WELWYN HATFIELD COUNCIL – DEVELOPMENT CONTROL
DELEGATED REPORT

APPLICATION No:	S6/2011/2513/FP
------------------------	------------------------

This application seeks full planning permission for the erection of boundary wall, gates and railings.

67, RIDGEWAY, CUFFLEY  
HERTFORDSHIRE EN  
PROPOSED NEW FRONT WALL  
AND GATES

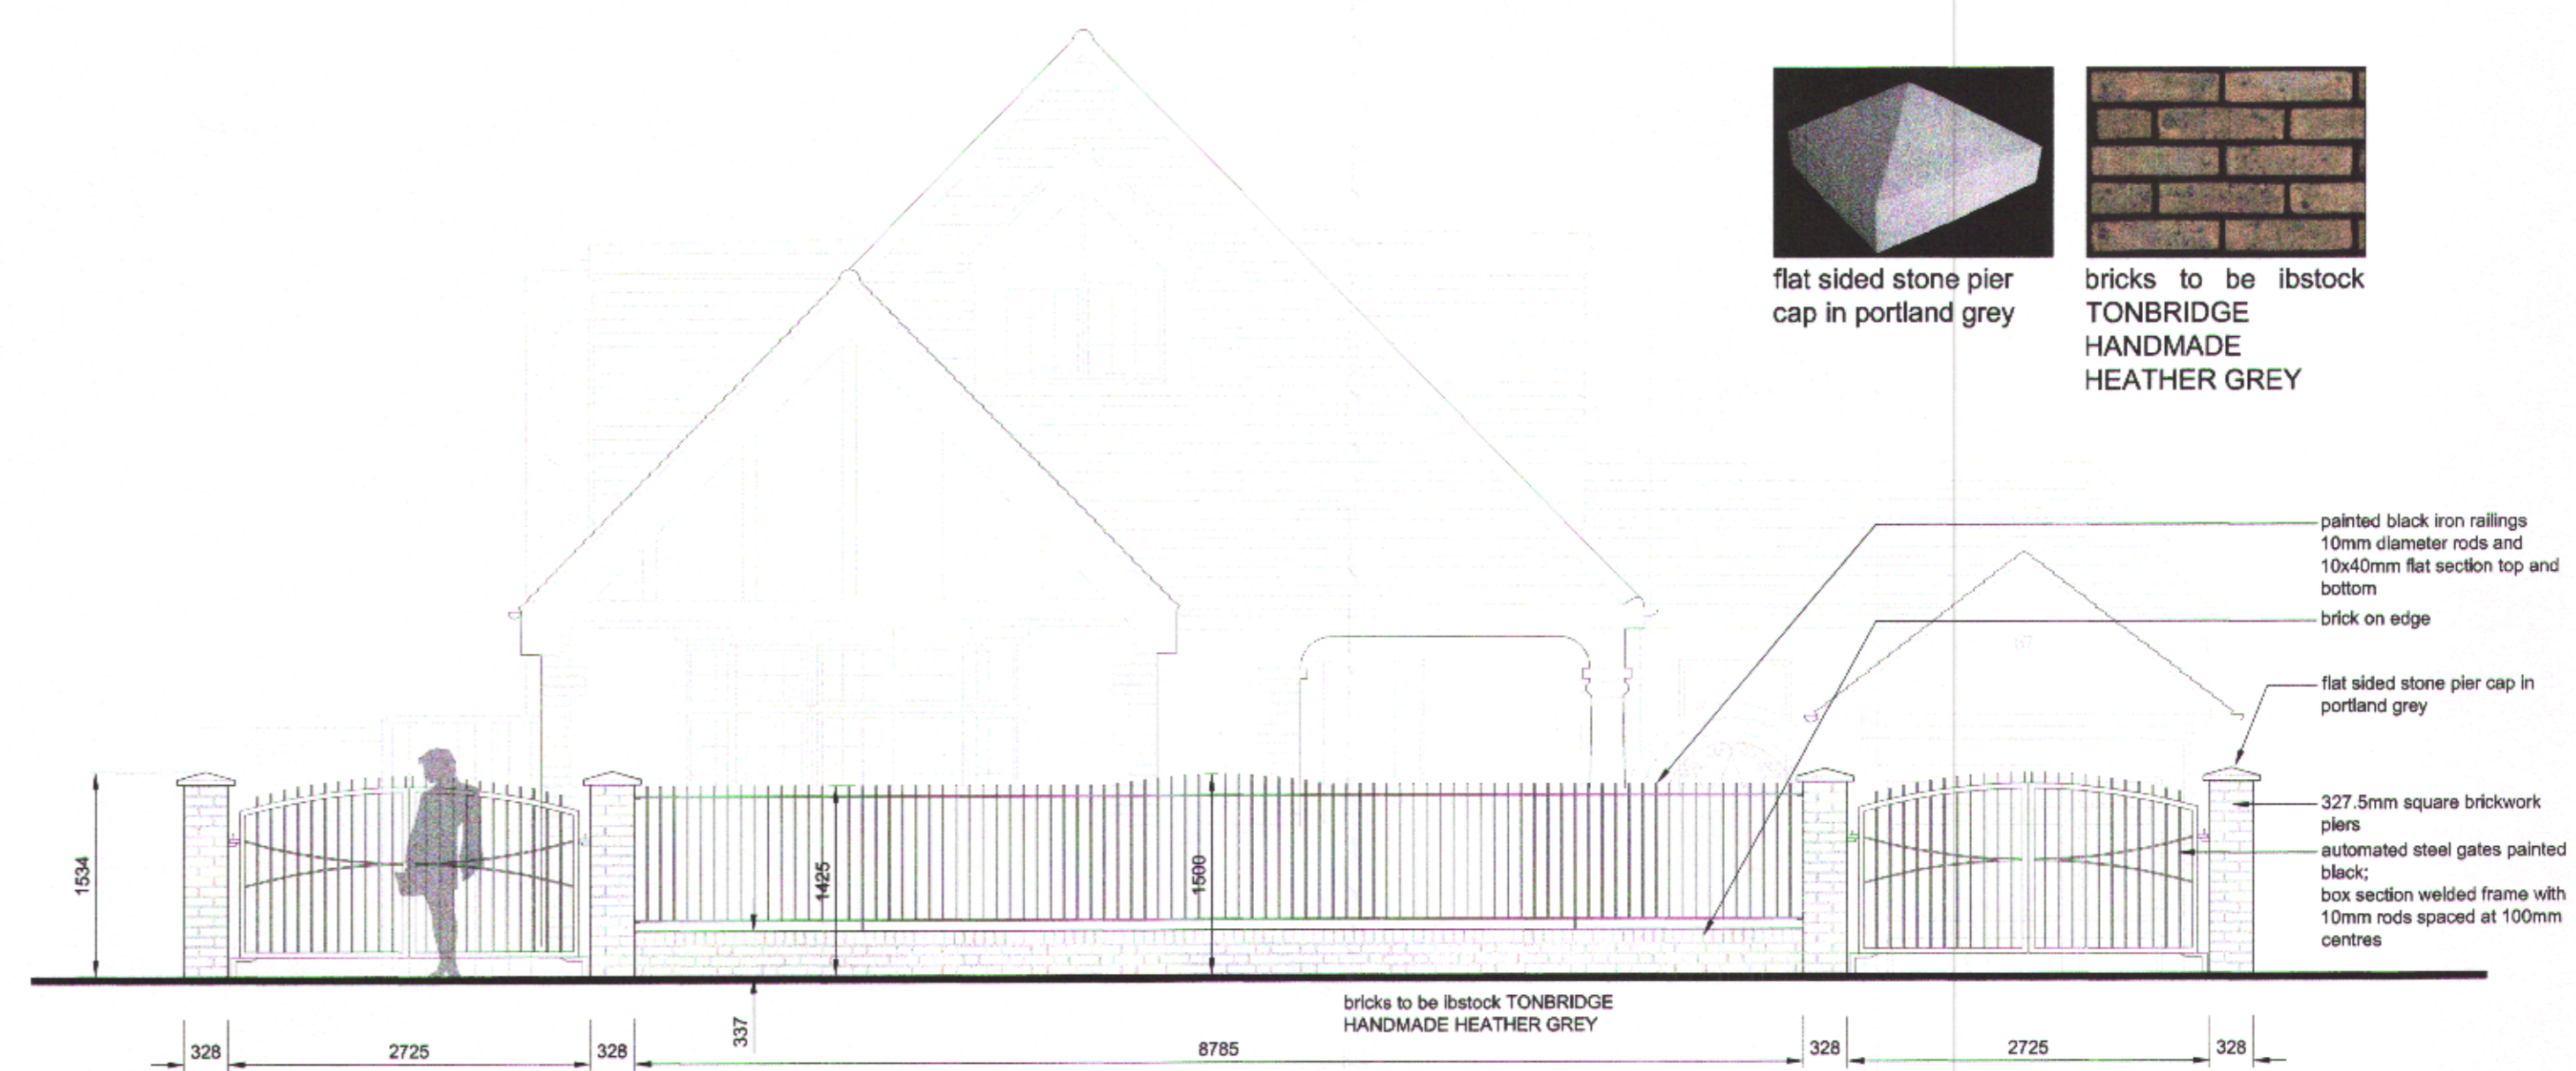
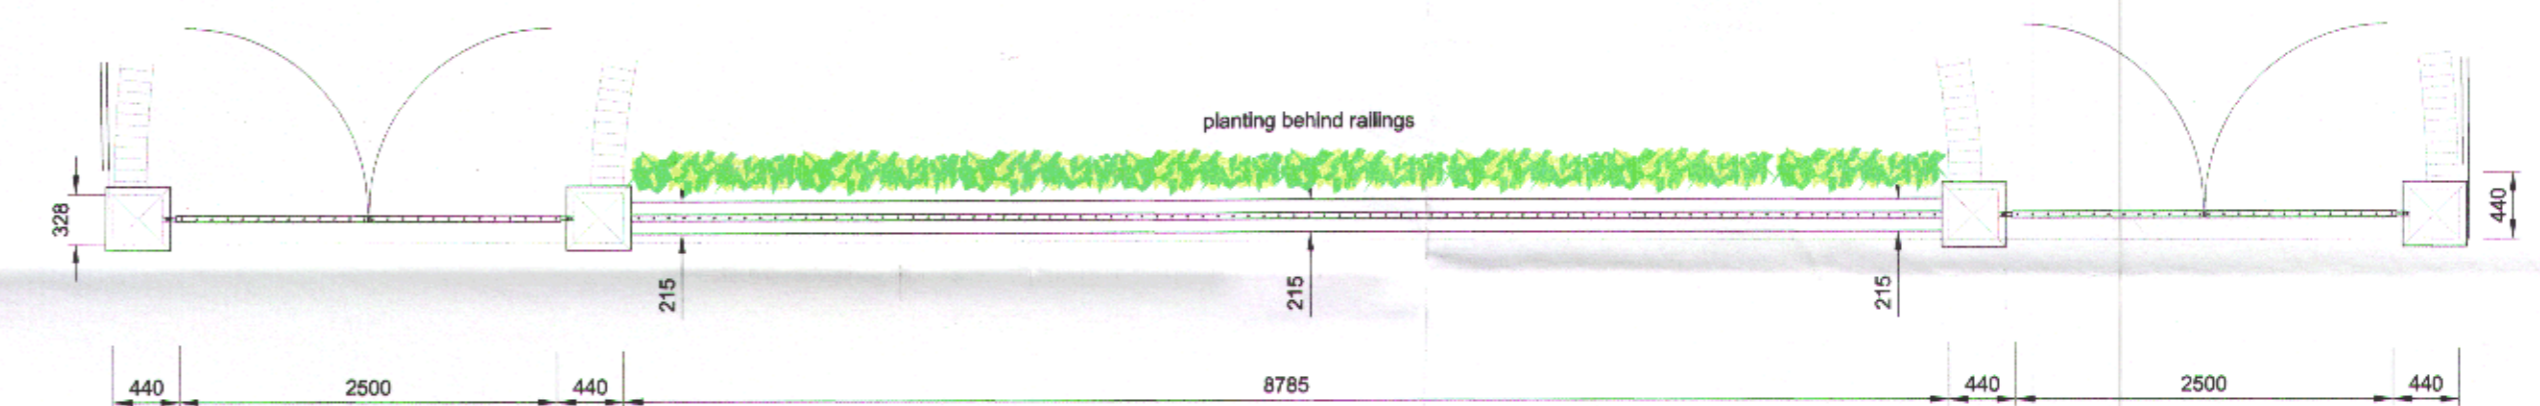
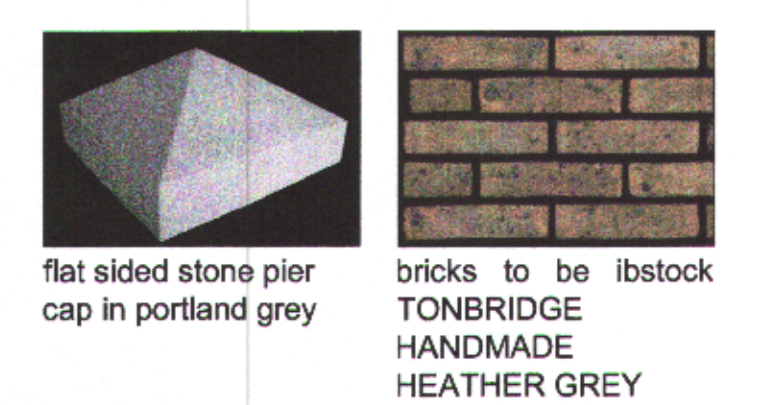
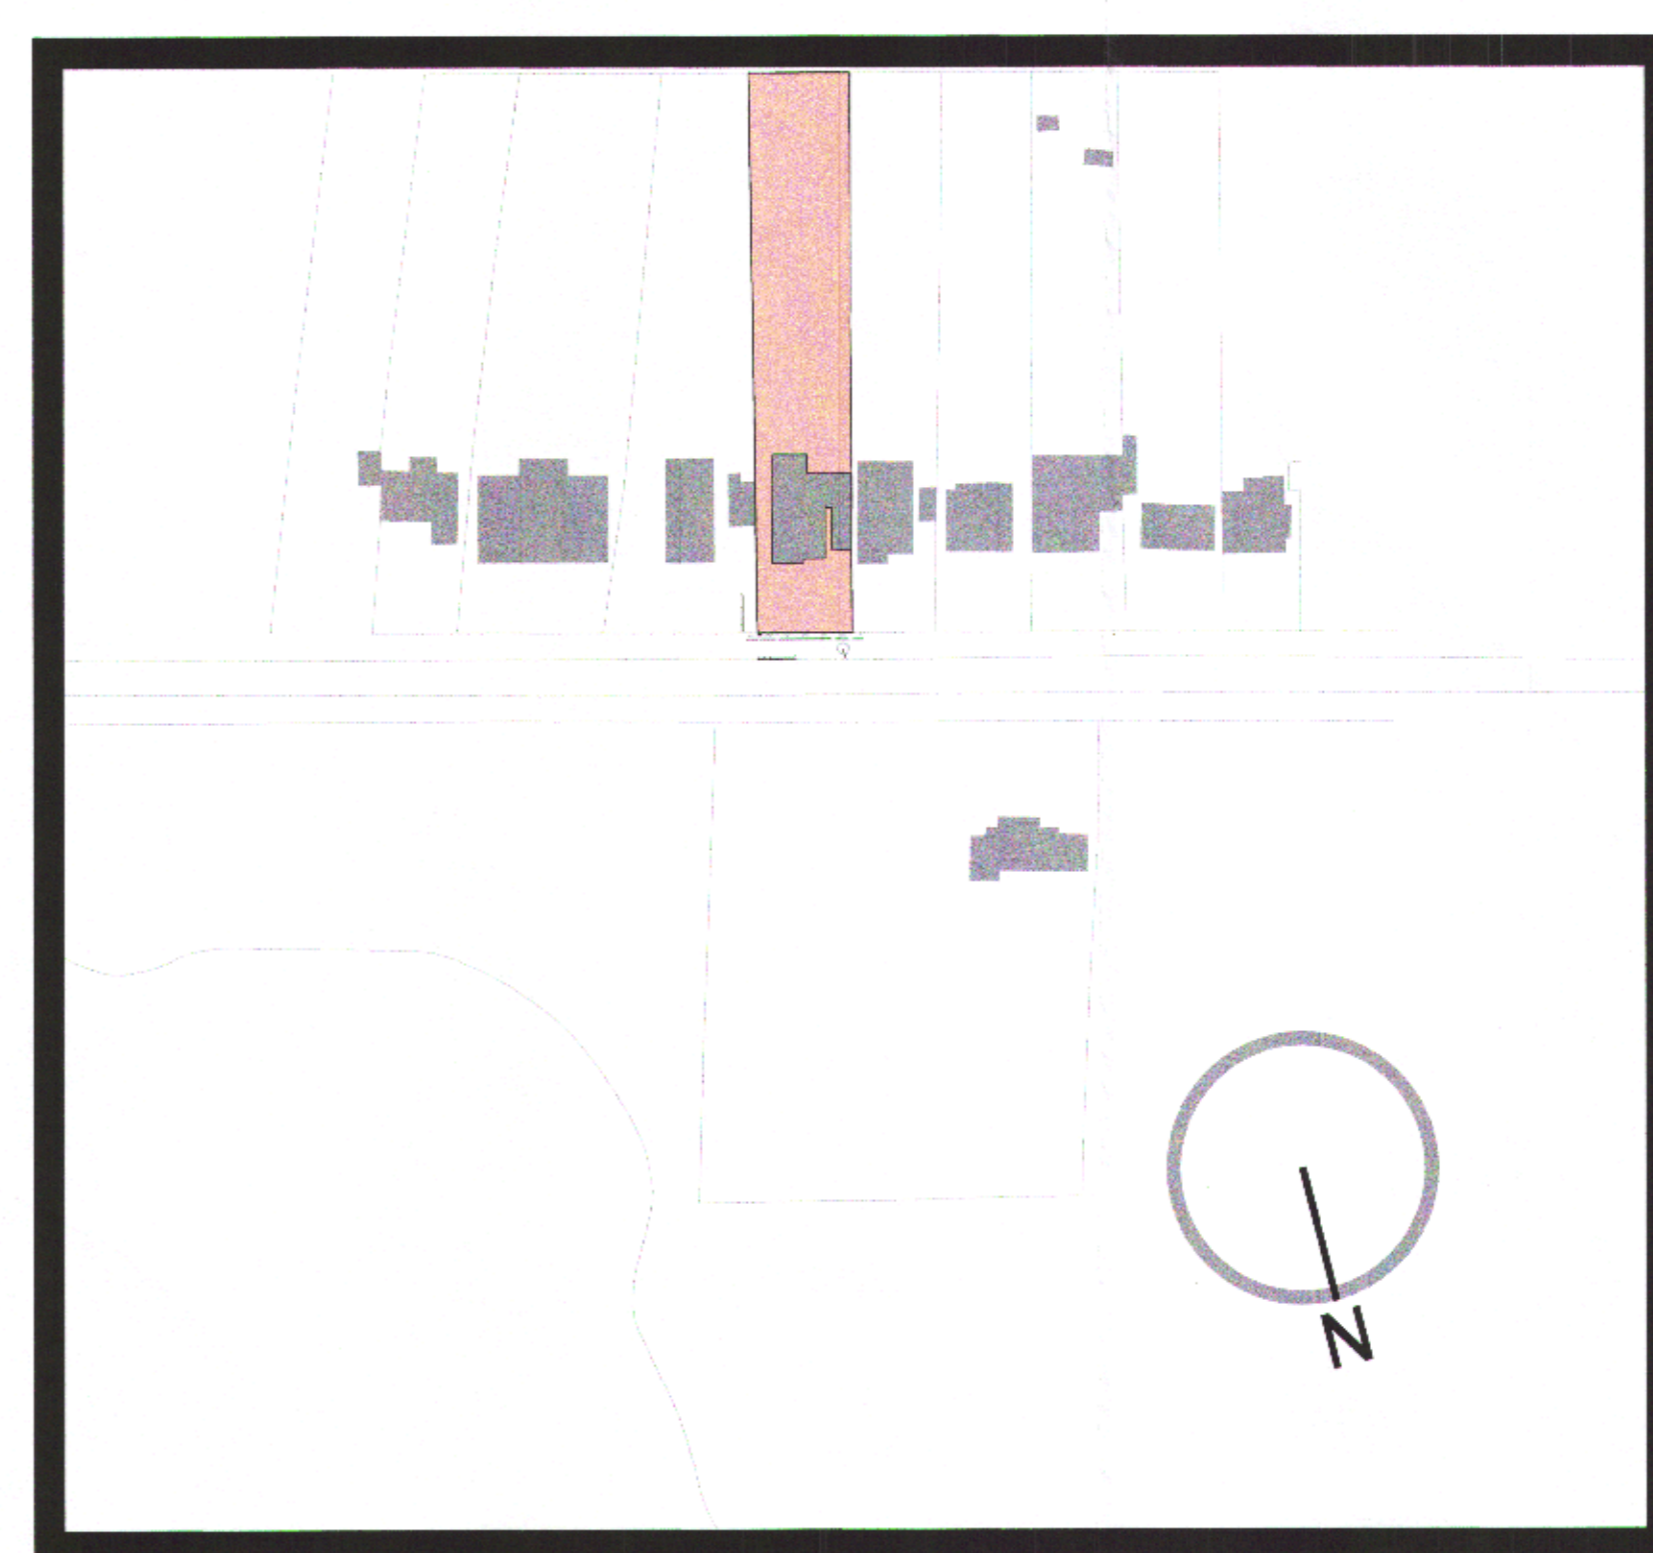
The Ridgeway is a classified road B157 and designated as a secondary distributor road. The submitted drawings do not show the distance between the gates and the edge of the carriageway although the Ordinance Survey based site plan indicates a 4.8m setback. A planning condition is suggested requiring the approved gates to be setback a minimum of 5m from the edge of the highway and to open inwards into the site. This would allow a vehicle to wait clear of the carriageway whilst the gates are opened and closed. Subject to the suggested condition, the proposal would not have an unreasonable impact on the safety and operation of the highway.

1. C.2.1 – Time Limit
2. C.13.1 – The development/works shall not be started and completed other than in accordance with the approved plans and details 001 Rev P2 received and dated 18 November 2011& 500 Rev P3 received and dated 10 January 2012
